25 April 2025

Our Ref: SEV001SSFI
Your Ref: ABP-321238-24

Re: Planning application for a 110 kilovolt electricity substation, approximately 7.5 kilometres of underground electricity line and all associated works at Moyvannan, Feamore, Lisbaun, Carrownolan, Carrowncloghan, Carrowkeeney, Ardmullan, Curraghboy, Gortnasythe, Derryglad, Eskerbaun, and Brideswell, County Roscommon.

FIGURE 14: ELECTRICITY LINE TRENCH SPECIFICATION

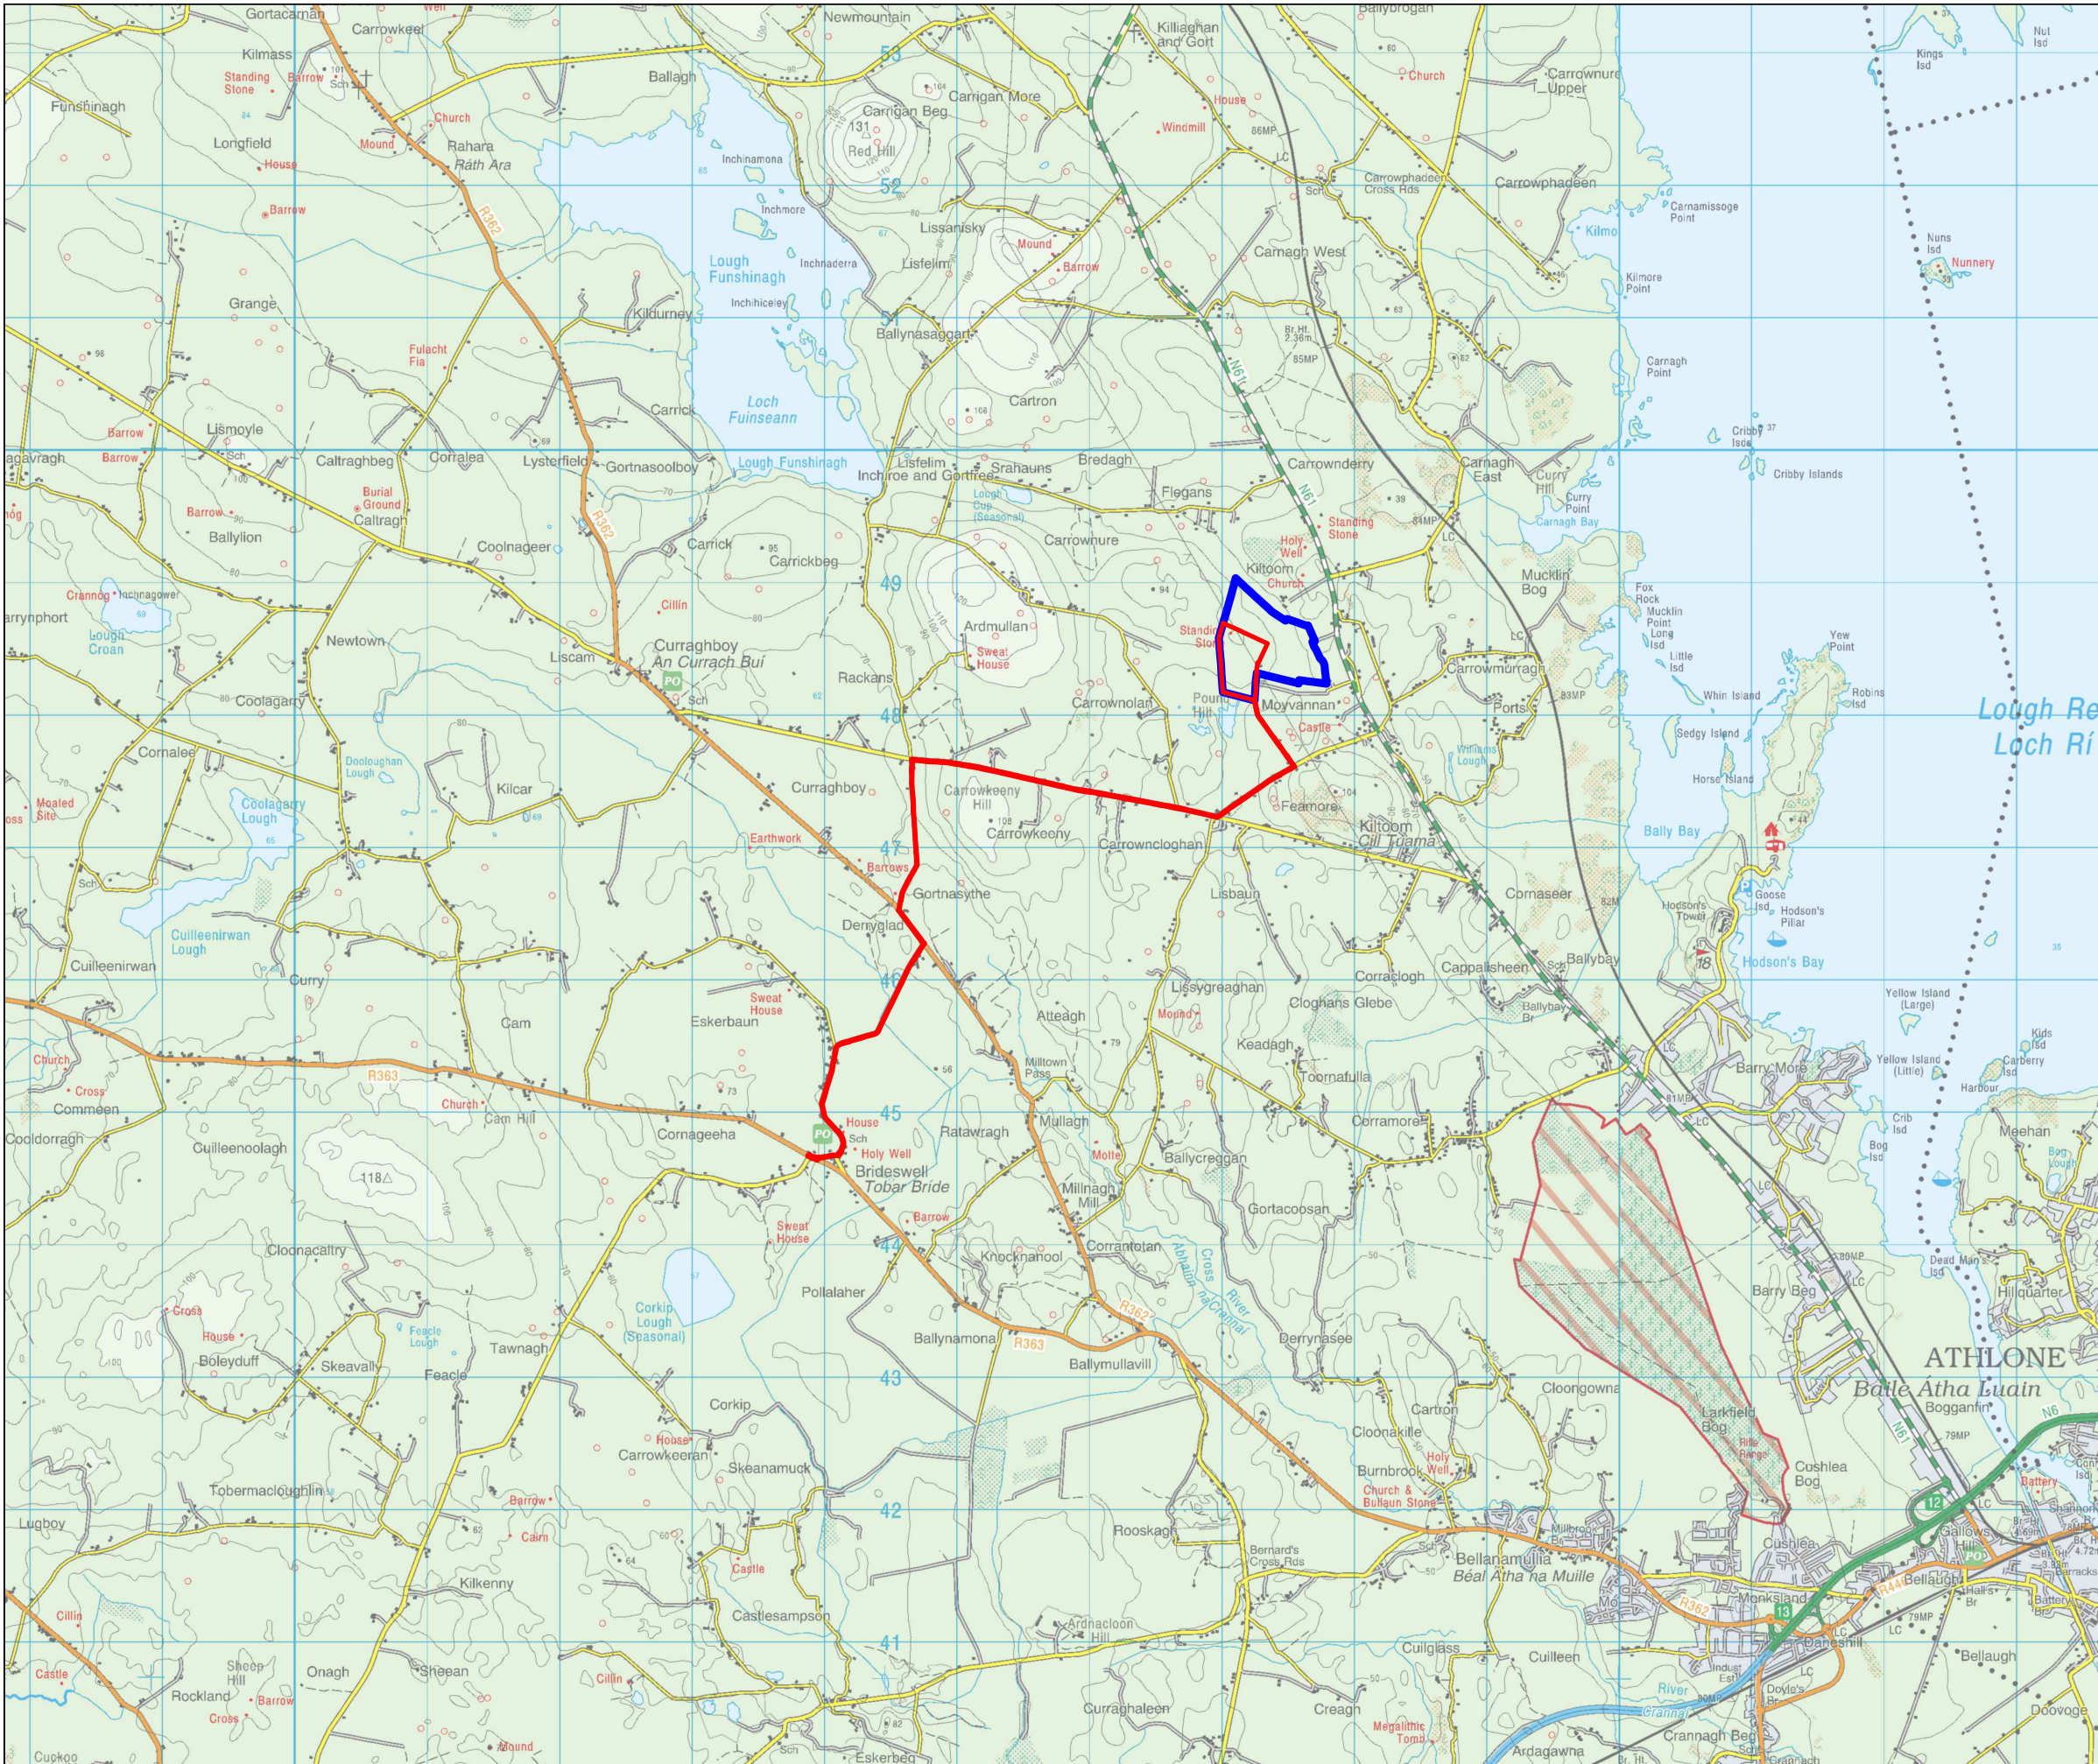
The Planning Authority expresses concern as to the long term effect which the proposed development may have on the local road network and considers that the proposed development may place significant constraints on it with regards to future works along the route of the underground electricity line.

The Planning Authority refers to a recommendation that the electricity line would be located a minimum of 1.2 metres from the road edge and notes that the recommendation has not been incorporated within the proposed development.

Notwithstanding the absence of any express request for a 1.2m separation distance to be implemented, the design process has, at all times, sought to minimise the extent of infrastructure to be installed within the paved surface of the relevant public roads. As is standard practice for the design of such proposed developments, every effort has been made to install infrastructure within the roadside verge to minimise excavations within the road surface, to minimise the effects on traffic flows and manage traffic via 'Stop/Go' systems as opposed to the requirement for full road closures.

Following a further design review of the proposed development in light of the comments of the Planning Authority, due to the absence or restricted availability of roadside verge, it will not be possible to maintain a separation distance of 1.2m from the road edge to the underground electricity line.

Drawing Title: **FIGURE 12: JOINT BAY SPECIFICATION**

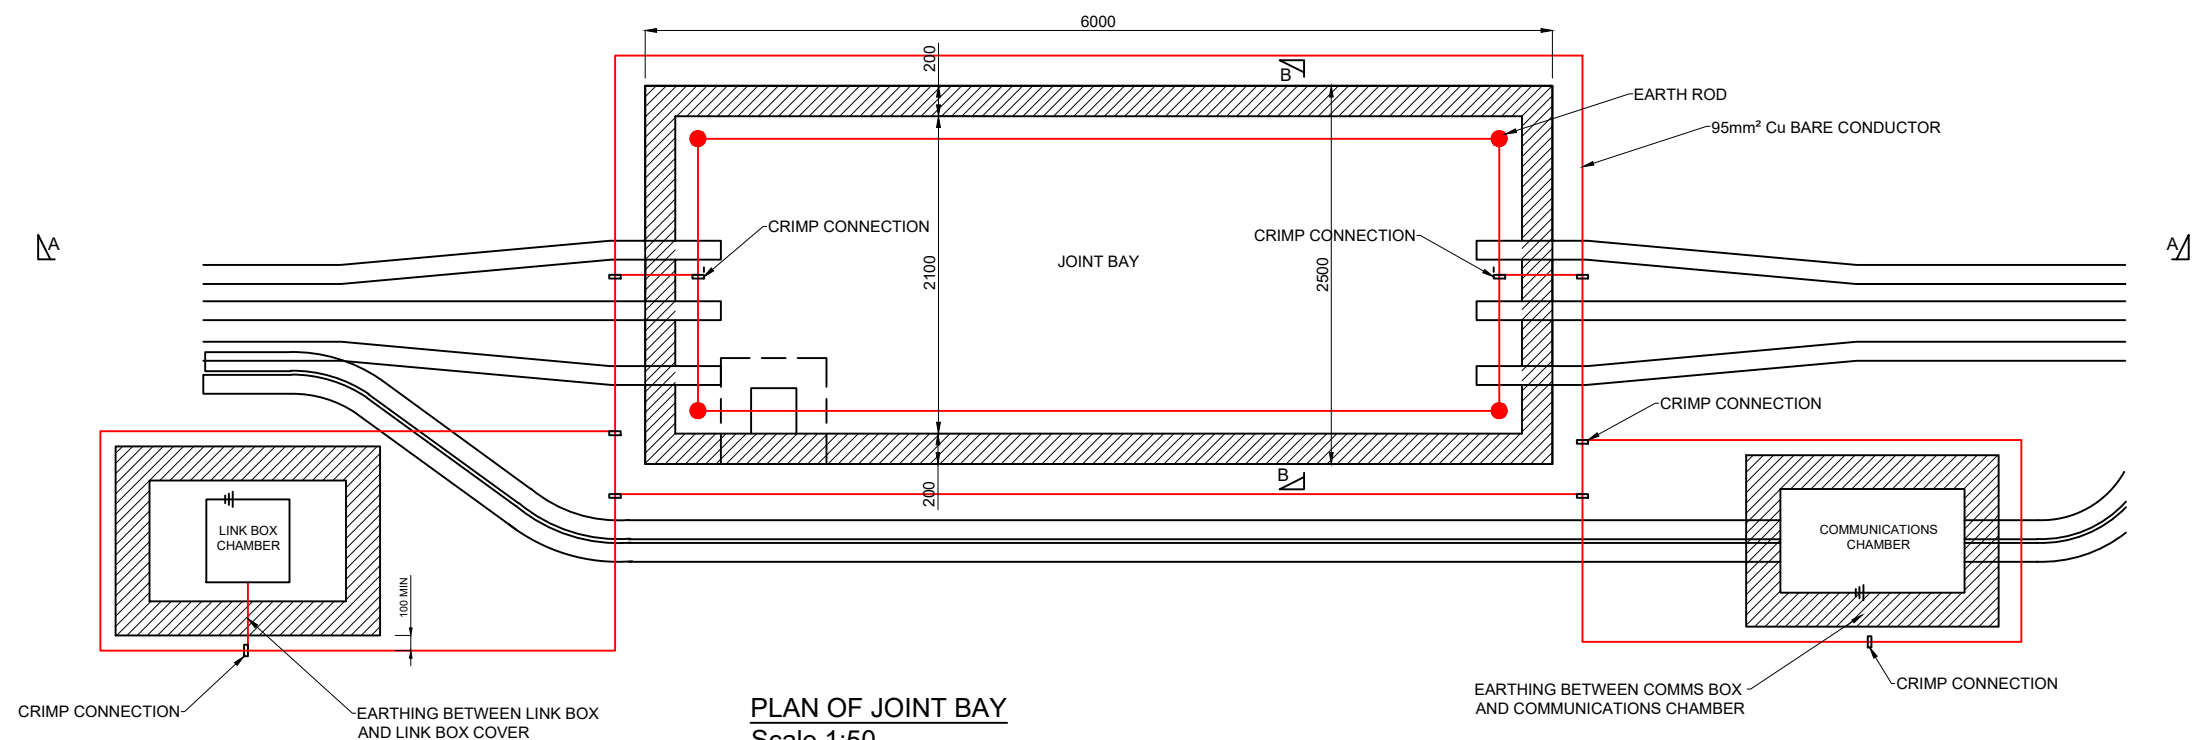
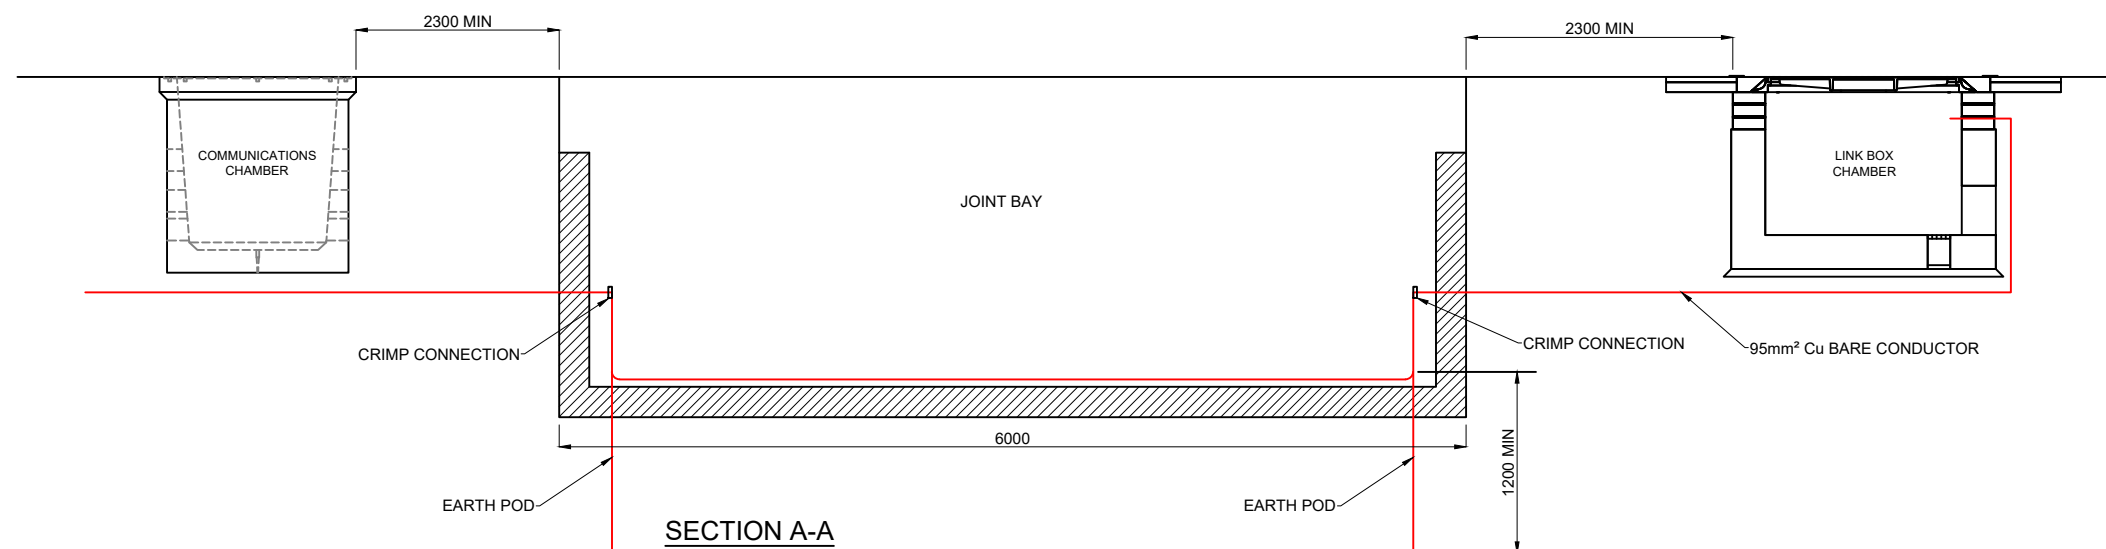
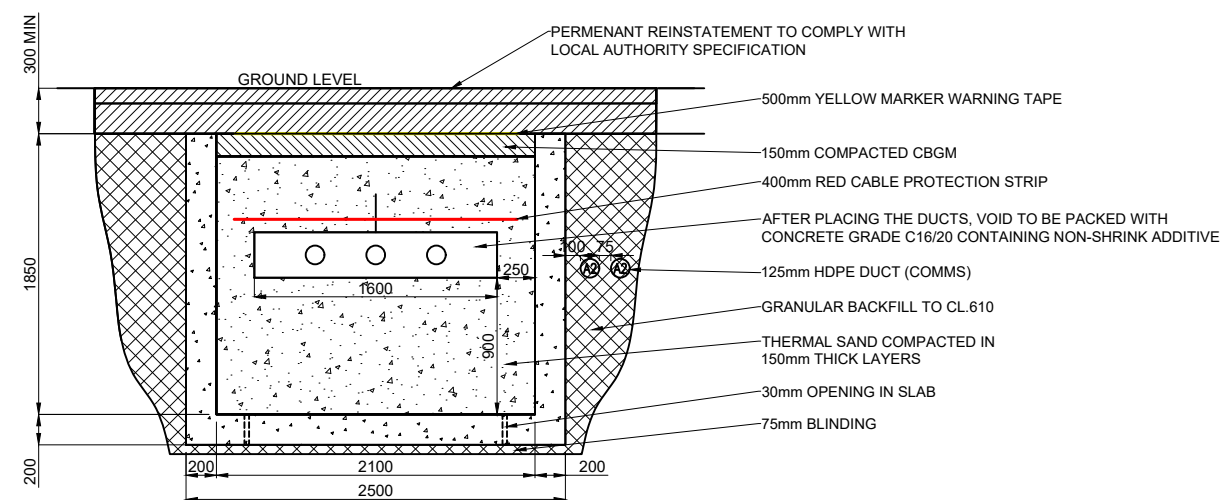
The Planning Authority asserts that the installation of joint bays will have a major impact on the public roads and that locations and depths of joint bays can only be approved following further consultation.

As described at Section 3.4.4 of Chapter 3 (Volume I) of the EIAR, the precise number of joint bays will be confirmed as part of the post-consent detailed design process. This detailed design process will also confirm the precise location of the joint bays within the public road corridor; however, as set out at Section 3.4.4 of Chapter 3

(Volume I) of the EIAR and discussed at length above, joint bays will be located within roadside verges or agricultural access points insofar as practicable to minimise the extent of joint bay infrastructure located within the paved carriageways.
